Recommendation Report for Planning Permission for Works or Extension to a Dwelling

REF NO: M/50/26/HH

LOCATION: 10 Central Drive
Middleton-on-sea
PO22 7TT

PROPOSAL: Demolition of existing access stairs and porch to side elevation. Construction of rear two storey extension and part first floor extension. New chimney and roof lights; realignment of existing roof terrace with frameless glass balustrade and replacement of handrails. Alterations to ground floor fenestration.

7. Site - Proposed
scale 1 : 200

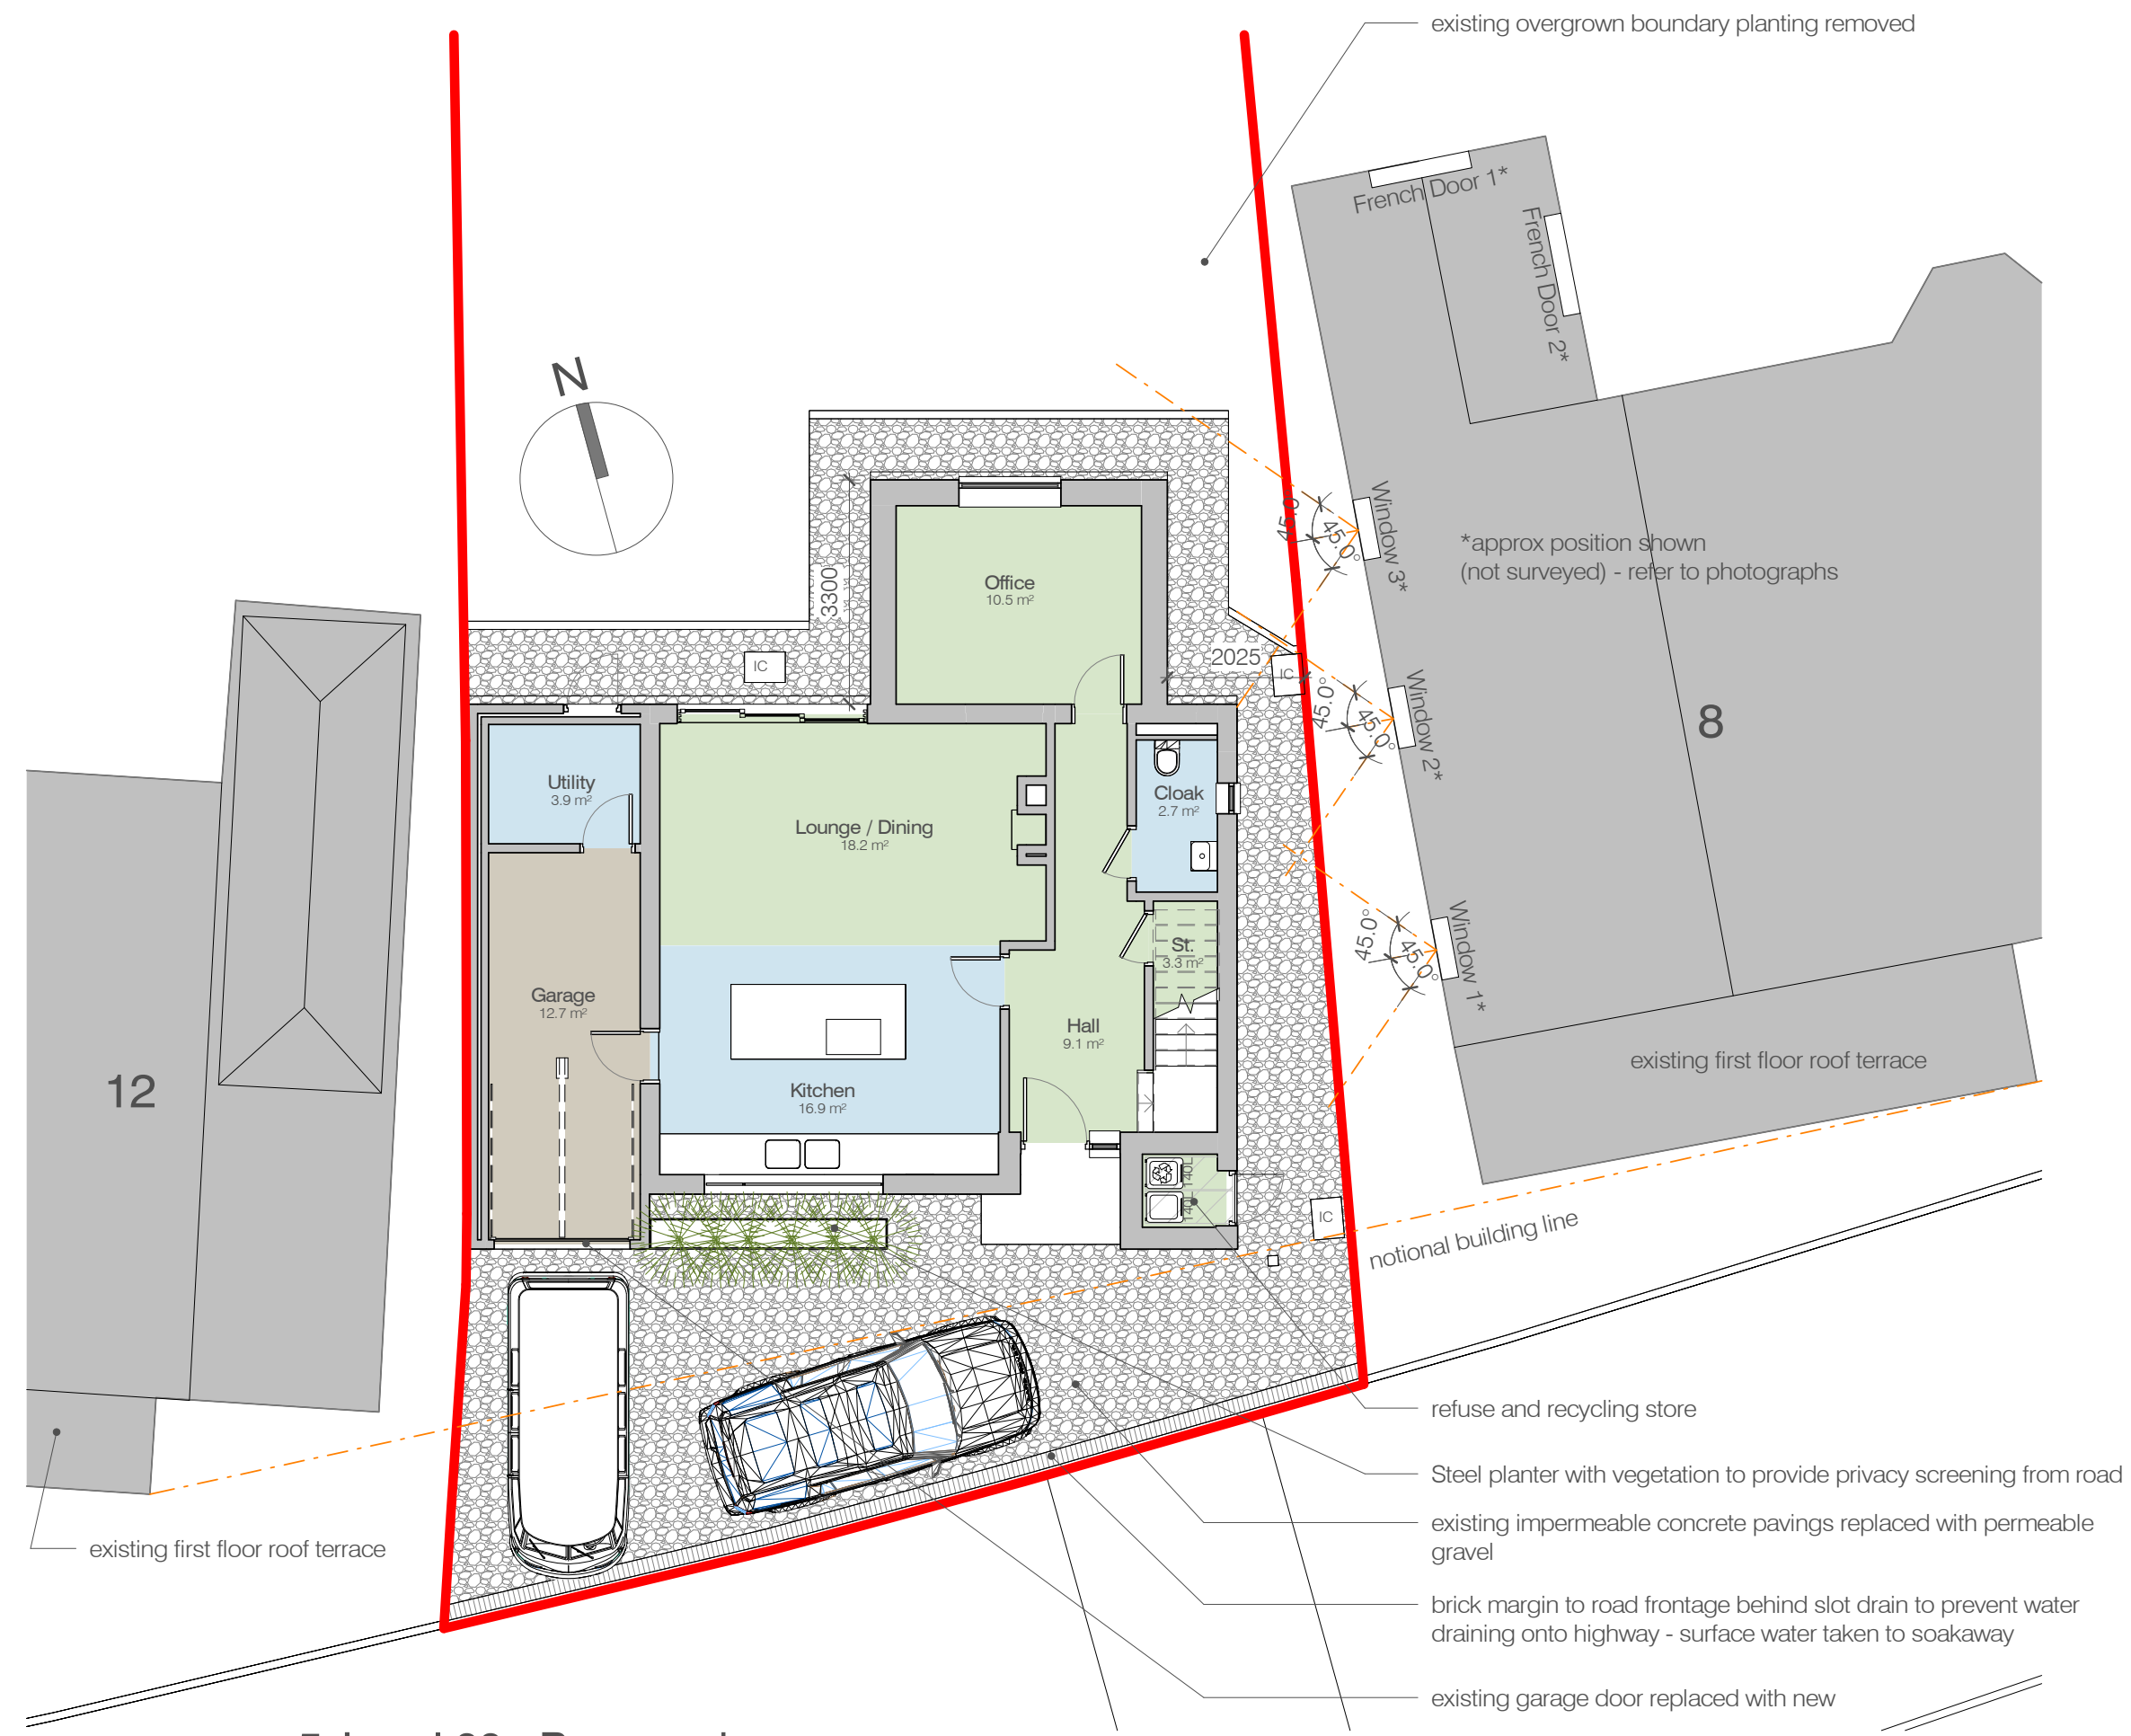
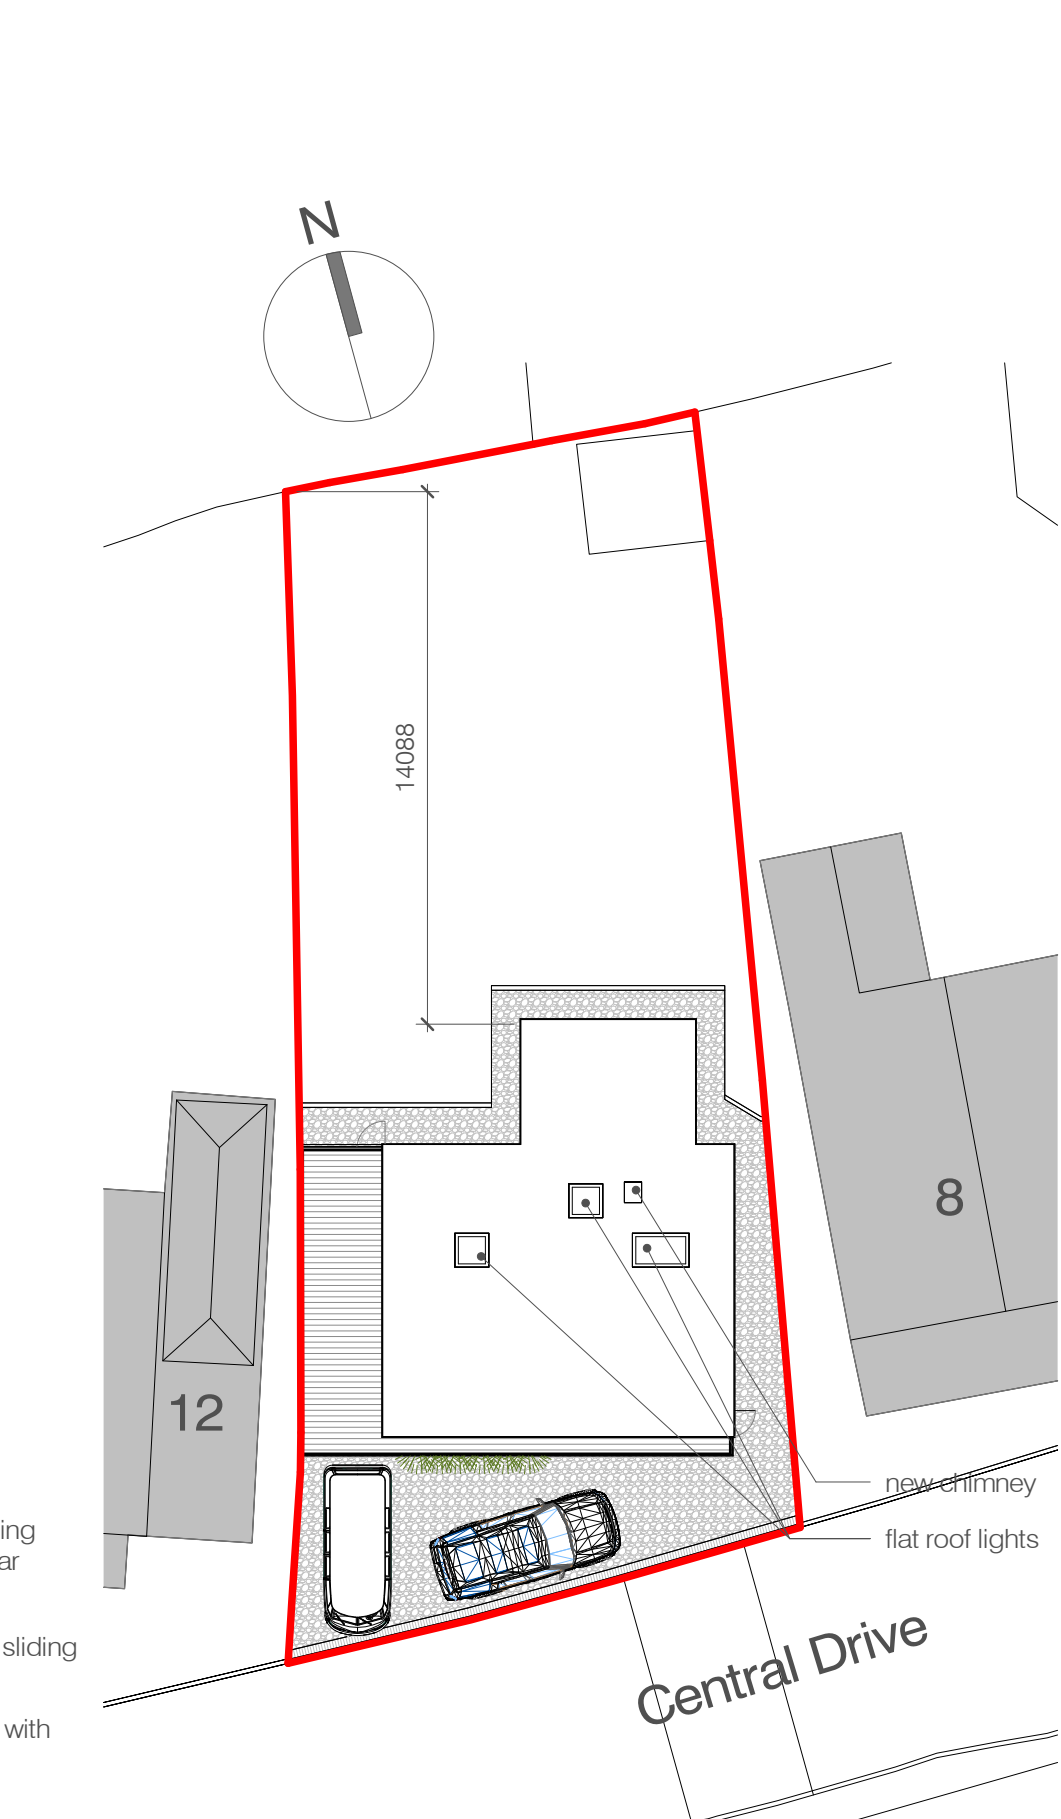
Insufficient information regarding surface water drainage has been submitted to evidence that flood risk will not be increased as due to the proposed development.

The designer proposes to drain surface water via a soakaway and permeable paving, including a slot drain to prevent water egress to the highway. We support the use of infiltration as the second highest priority method of surface water disposal (after water reuse); however, the necessary evidence to demonstrate that infiltration is viable has not been provided. Fundamental information, such as groundwater monitoring data and infiltration testing results, have not been submitted. Should infiltration be proven unviable, an alternative method has been proposed by the designer, namely attenuation with a restricted discharge, however no final discharge location has been confirmed. Consequently, it has not been demonstrated that the site can be sustainably drained, and we object to the proposal.

The proposed extensions would remove some hardstanding, including the porch and stairs, and the majority of the extensions would be constructed over existing hardstanding. It is noted that part of the rear extension would extend over existing grass; however, given that the vast majority of the proposed development would be constructed over existing hardstanding, it would not be reasonable to refuse planning permission in this instance, particularly as the dimensions are similar to those achievable under permitted development. An informative is attached to the planning consent outlining appropriate drainage interception features for development of this scale.

Given that the proposed extensions would be constructed over an area that currently comprises some hardstanding, refusal on drainage grounds would not be reasonable in this instance. The proposals would not increase flood risk elsewhere and would accord with policies W DM1 and W DM3 of the ALP.
